Our ref: HA/2021/123283/01-L01
Your ref: P/68/21/PL
Date: 28 June 2021

**PART CHANGE OF USE OF EXISTING AMUSEMENT ARCADE TO MANAGERS
ACCOMMODATION (RESUBMISSION FOLLOWING P/48/20/PL)**

**PAGHAM BEACH AMUSEMENT ARCADE, 129 EAST FRONT ROAD, PAGHAM, PO21
4SX**

Drawing Title:
EXISTING PLANS AND ELEVATIONS

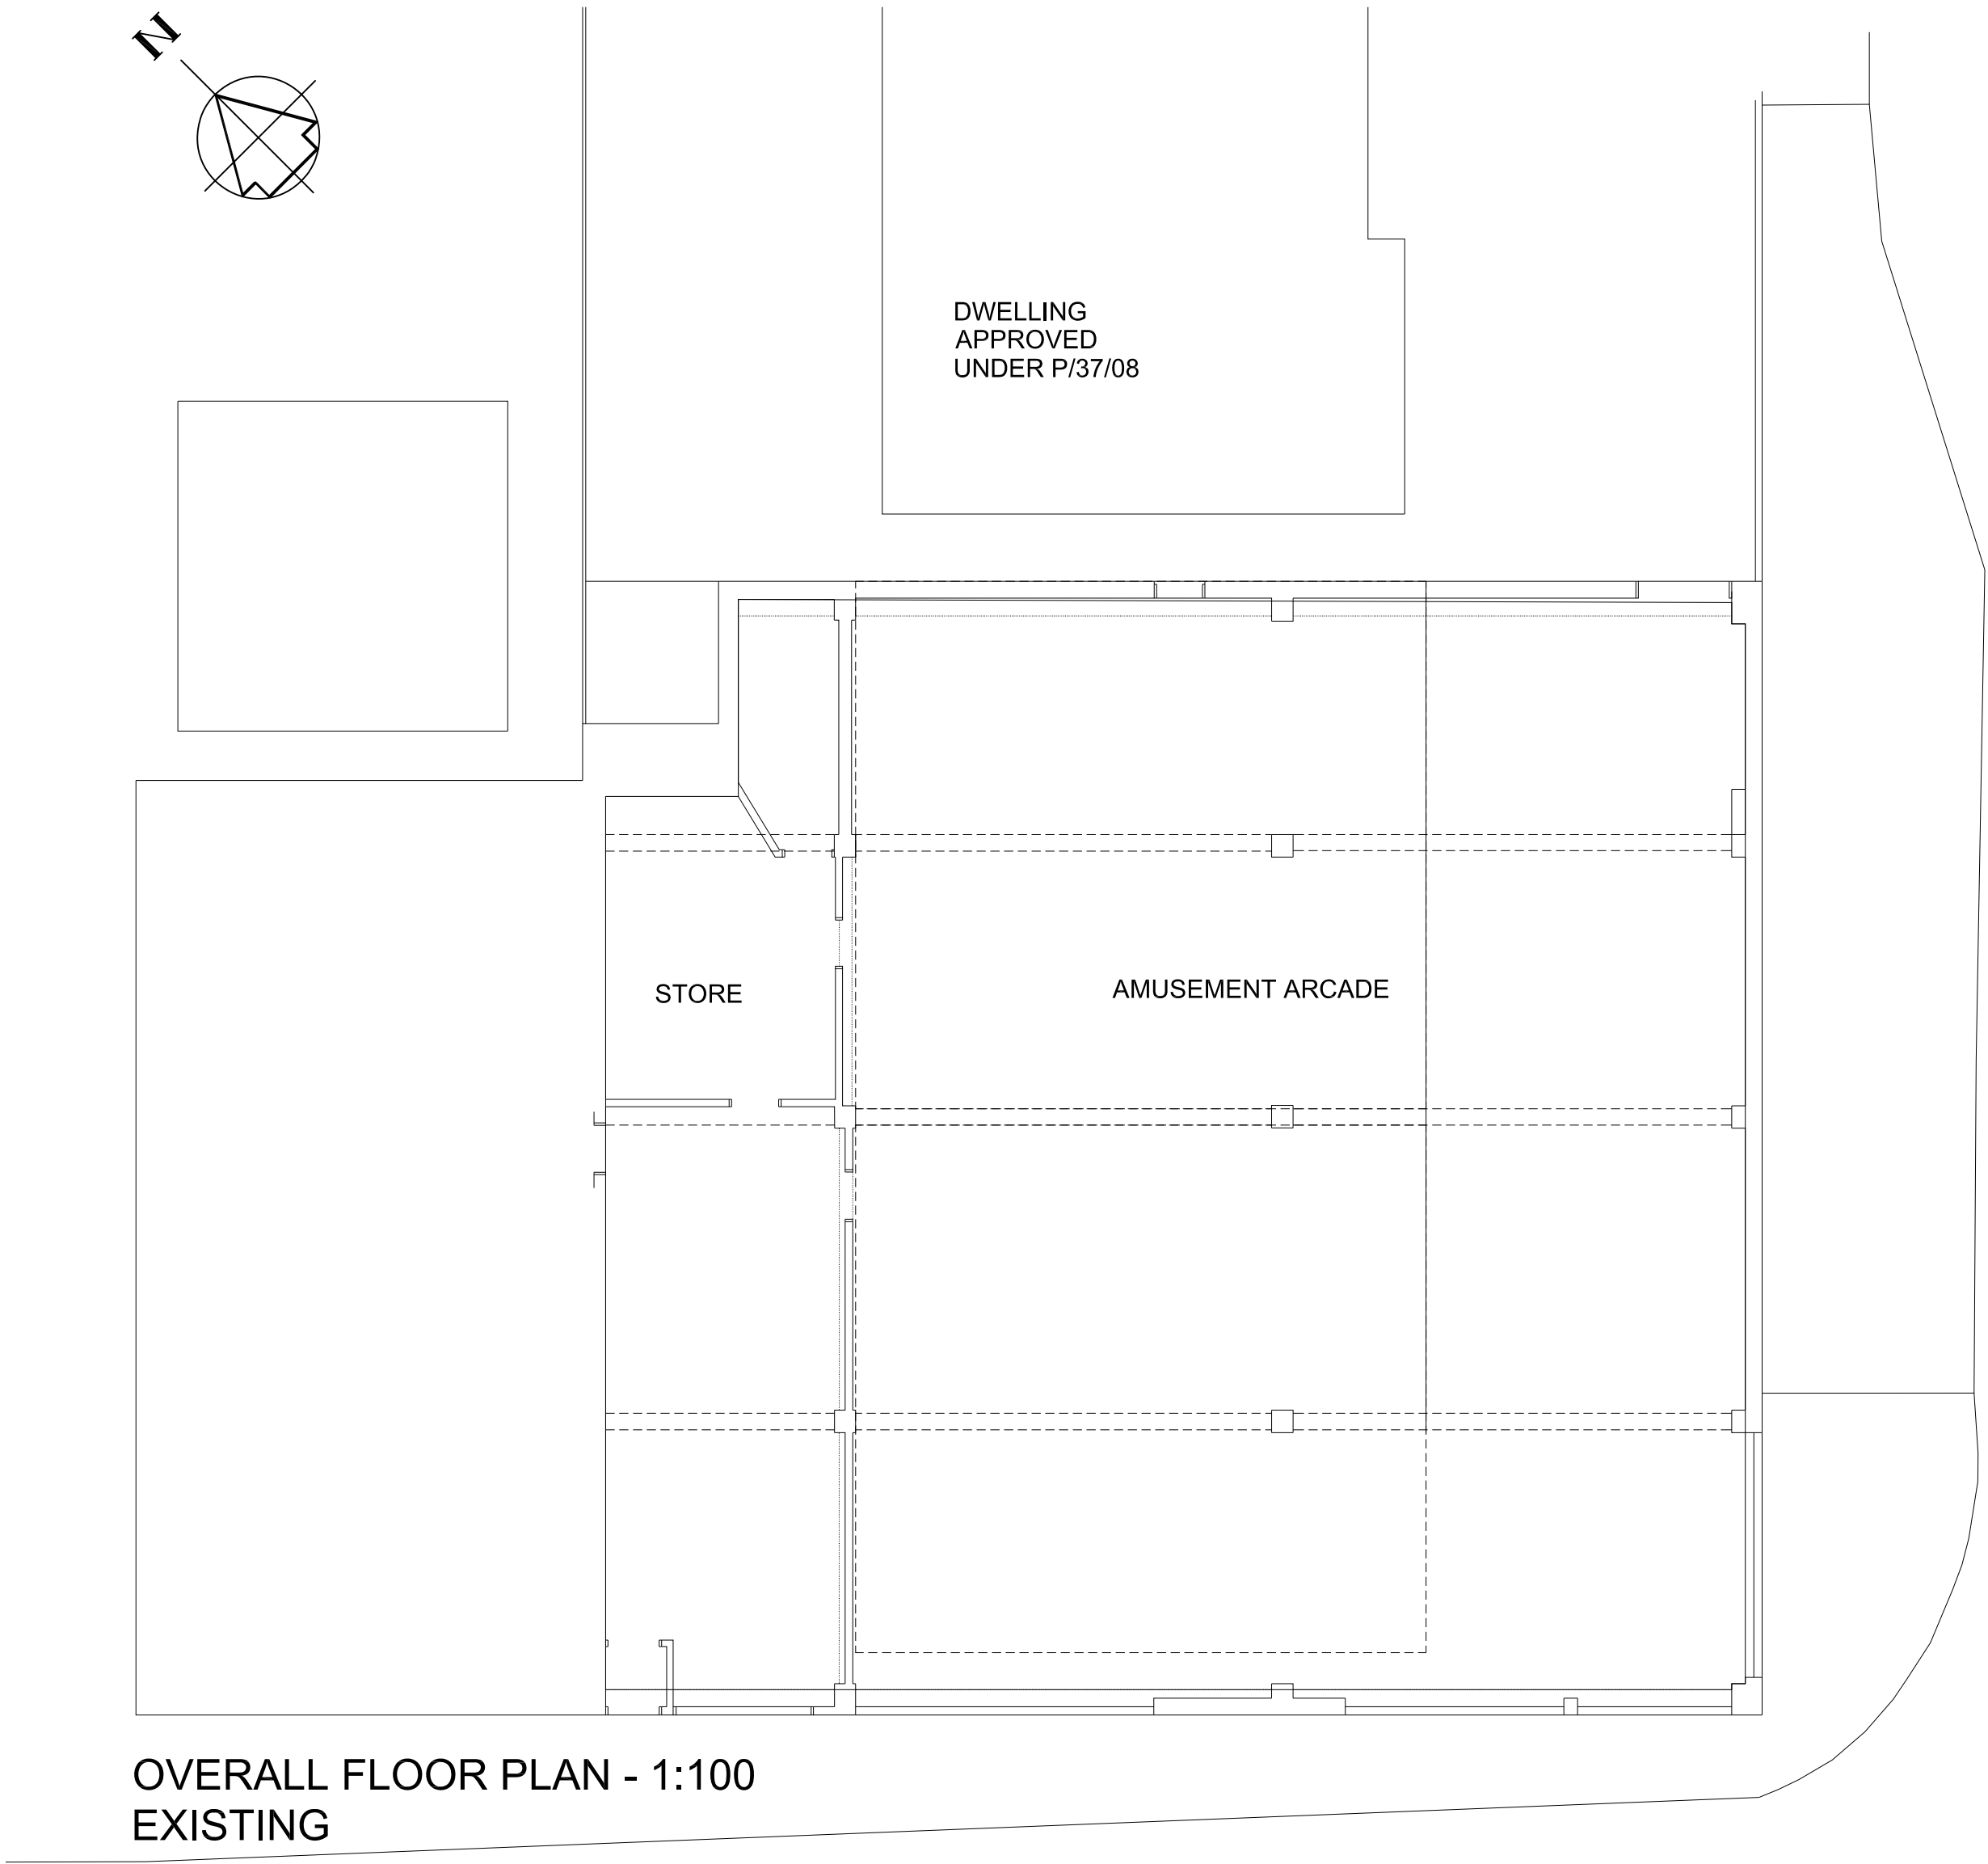
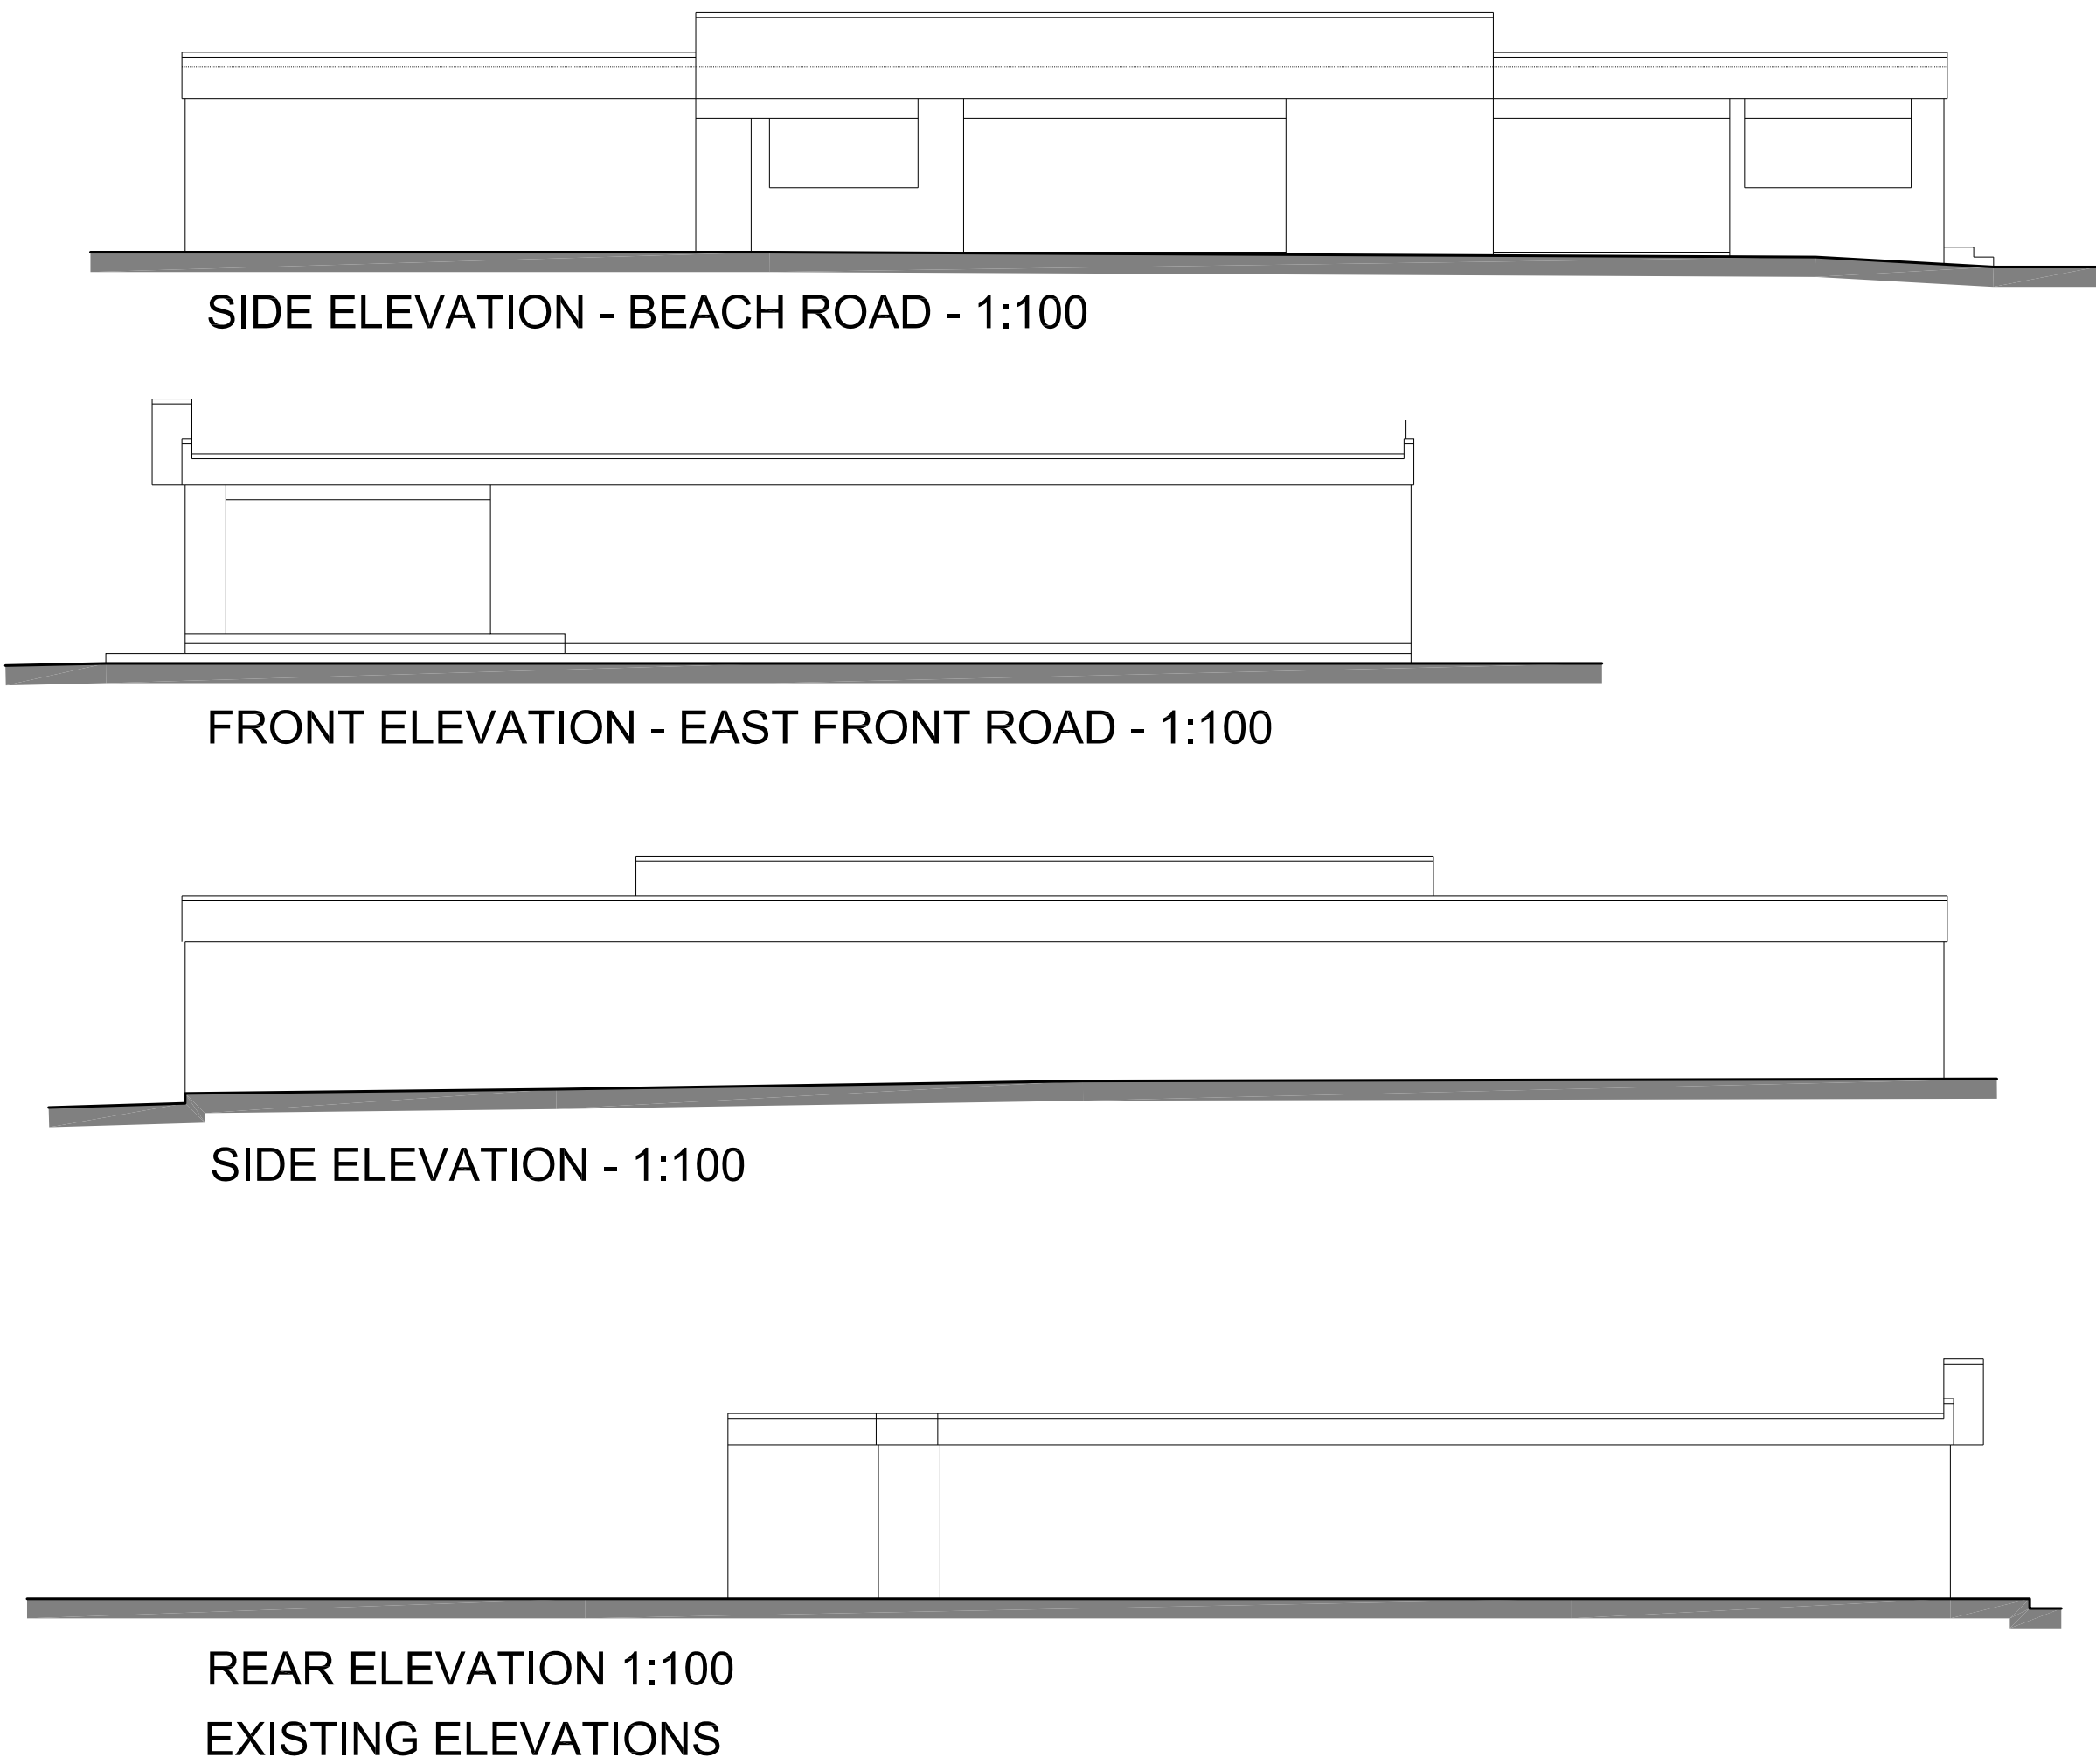
The submitted FRA does not comply with the requirements for site-specific flood risk assessments, as set out in paragraphs 30 to 32 of the Flood Risk and Coastal Change section of the planning practice guidance. The FRA does not therefore adequately assess the flood risks posed by the development. In particular, the FRA fails to:

- Take the impacts of climate change into account and provide a comparison between finished floor levels and modelled flood levels
- Consider how a range of flooding events (including extreme events) will affect people and property
- Consider the requirement for flood emergency planning including flood warning and evacuation of people for a range of flooding events up to and including the extreme event

We would recommend that sleeping accommodation is placed at least 300mm above the modelled flood levels (0.5% plus climate change allowances 2125), reducing the risk to occupants for the lifetime of the development.

To overcome our objection, the applicant should submit a revised FRA and amended plans which addresses the points highlighted above.

If this cannot be achieved, we are likely to maintain our objection. Please re-consult us on any revised FRA submitted and we'll respond within 21 days of receiving it.
